REPORT UPDATE

Application No: AL/72/22/PL

REF NO: AL/72/22/PL

PROPOSAL: Demolition of Servac Int workshops keeping certain structures and features, to renovate them in to a 2 No carport, with storage loft and re-landscaping to provide new gardens and biodiversity zones. This application may affect the setting of a listed building and is in CIL Zone 3 (Zero Rated) as other development.

West elevation (Roadside)
1:50 @ A1

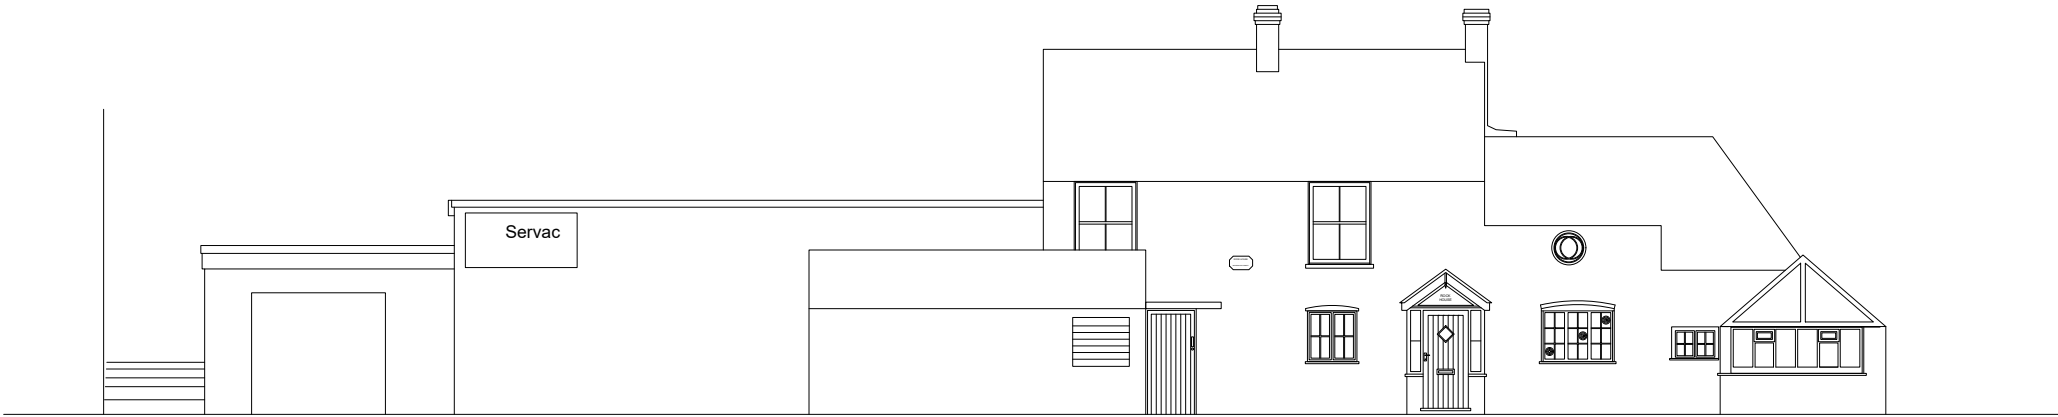
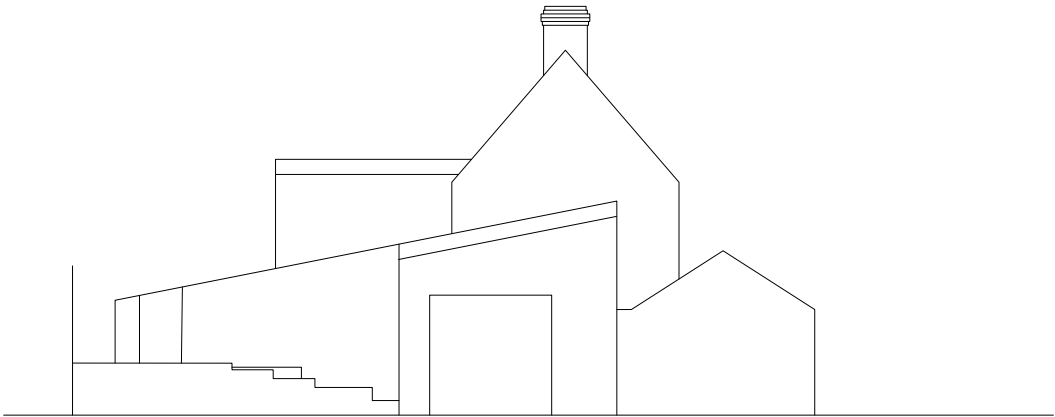
The proposal is considered to conflict with the relevant Development Plan policies in that by reason of the height and visual dominance of the first floor above the car port there would result in a materially adverse effect on the visual amenities of the locality and the setting of the adjacent listed building, and it would have an adverse impact upon the established character of the surrounding area. In addition the applicants have failed to meet the requirements of Policy EMP DM1 of the ALP and EE2 of the ANDP.

The height and mass of the building will exceed anything currently found on this section of the site and rival the scale of the main house to the south. The carport and continuation of an additional section of 4.2m high wall connecting the existing workshop wall to the proposed carport building will introduce additional bulk and height not previously experienced when viewing the site from the north and west.

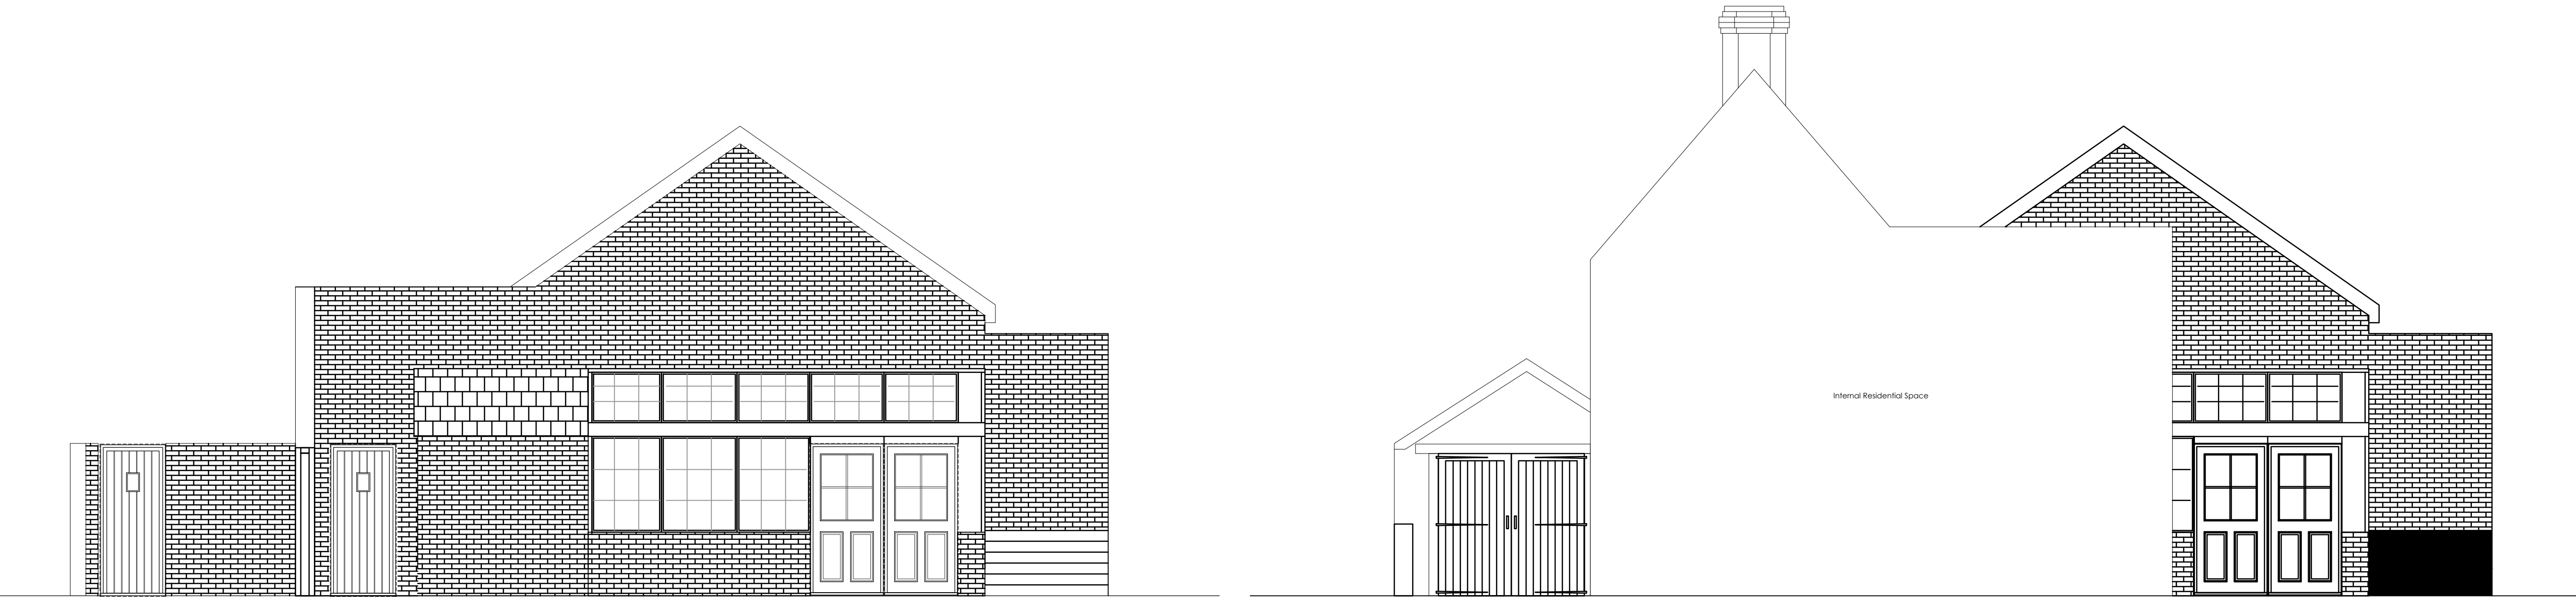
0353 PO2 (Layout Amended 28.09.22) Proposed East and South

- an additional south elevation 2 and an additional window and archway in the east elevation.

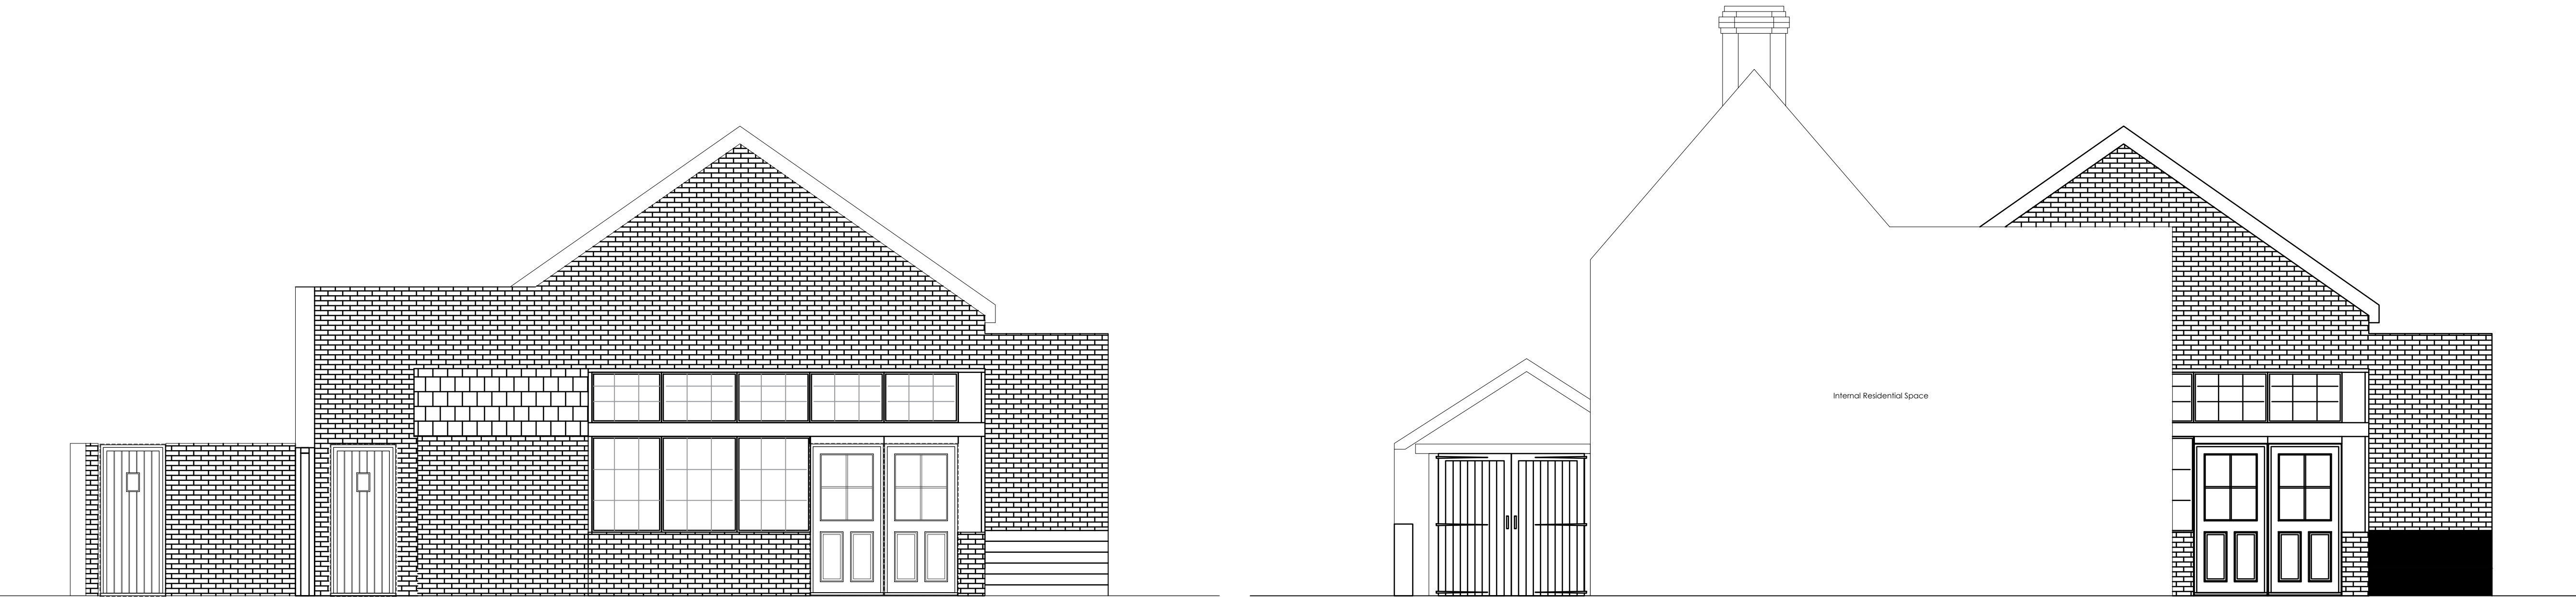
0350 PO2 (Layout Amended 28.09.22) General Arrangement Elevation - Proposed West (Roadside) and North

- different height of boundary treatment on far right of drawing.
- includes west elevation roadside with gate.
- north elevation shows gate piers.
- door on front elevation of house omitted.

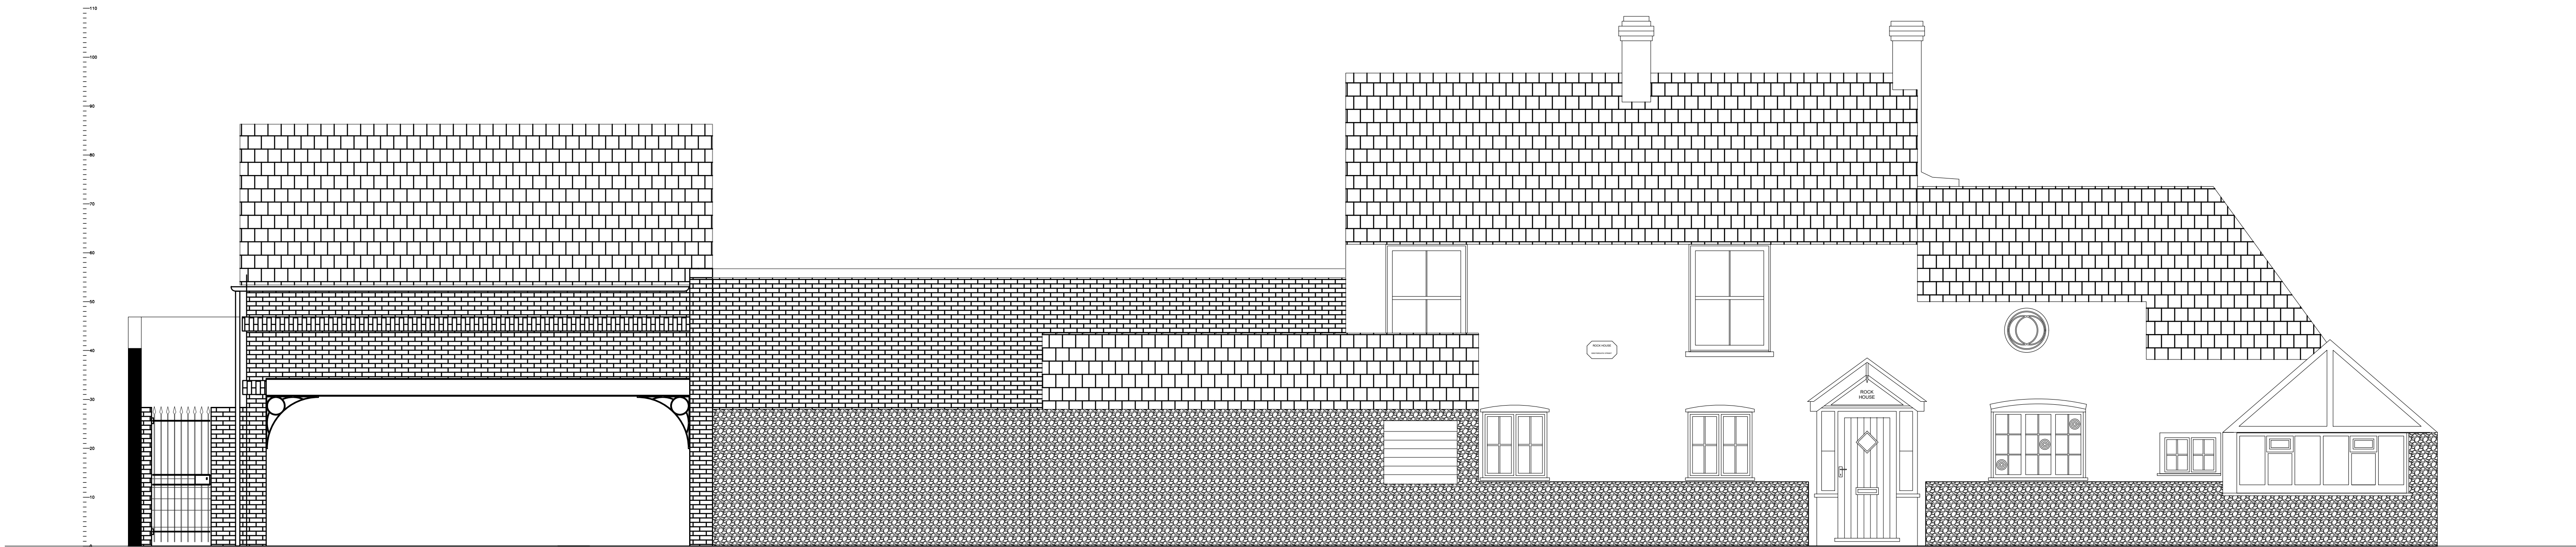
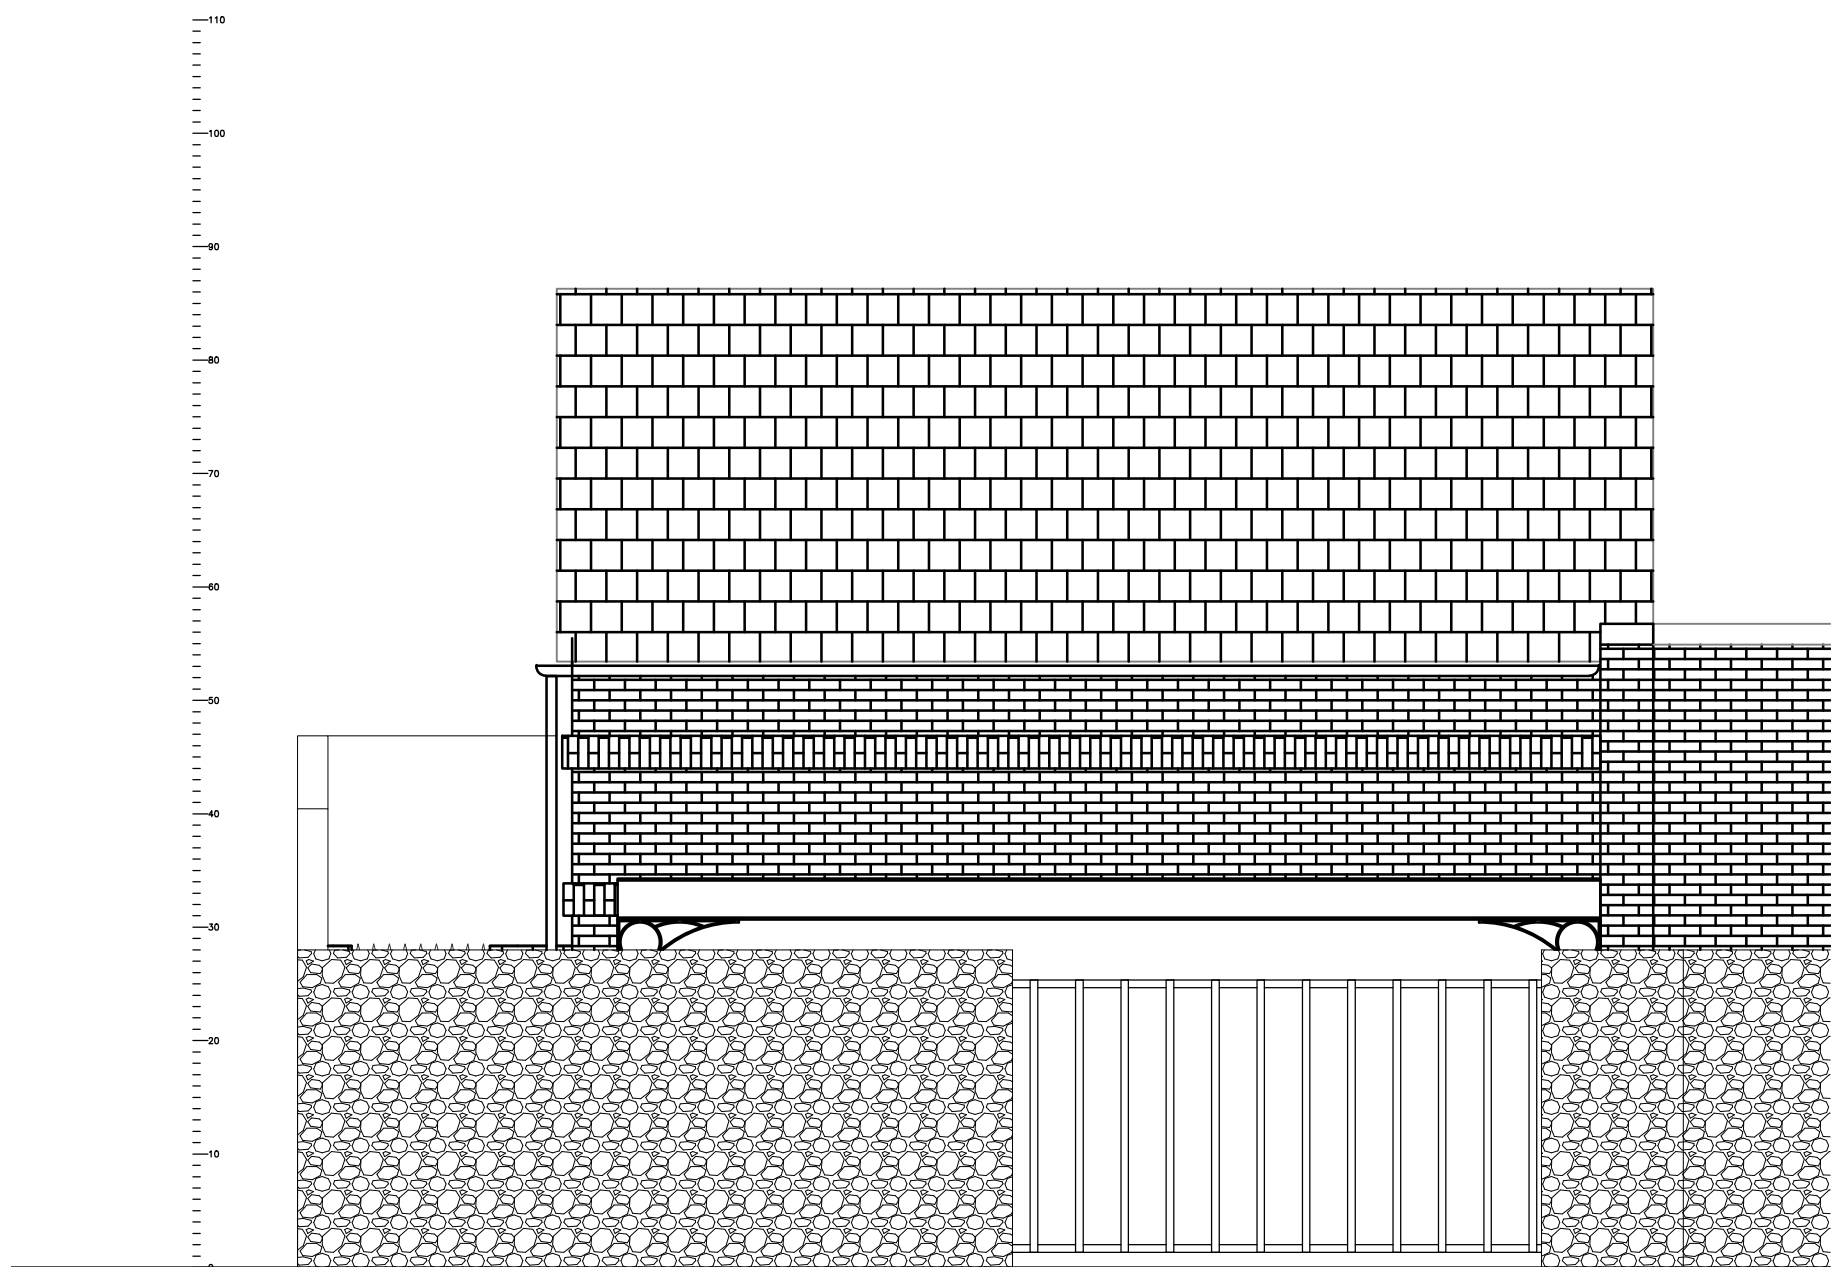
0250 PO2 (Layout Amended 28.09.22) General Arrangement Ground Floor Proposed

- window to living room.
- windows in office at front.
- opening on south elevation of workshop.
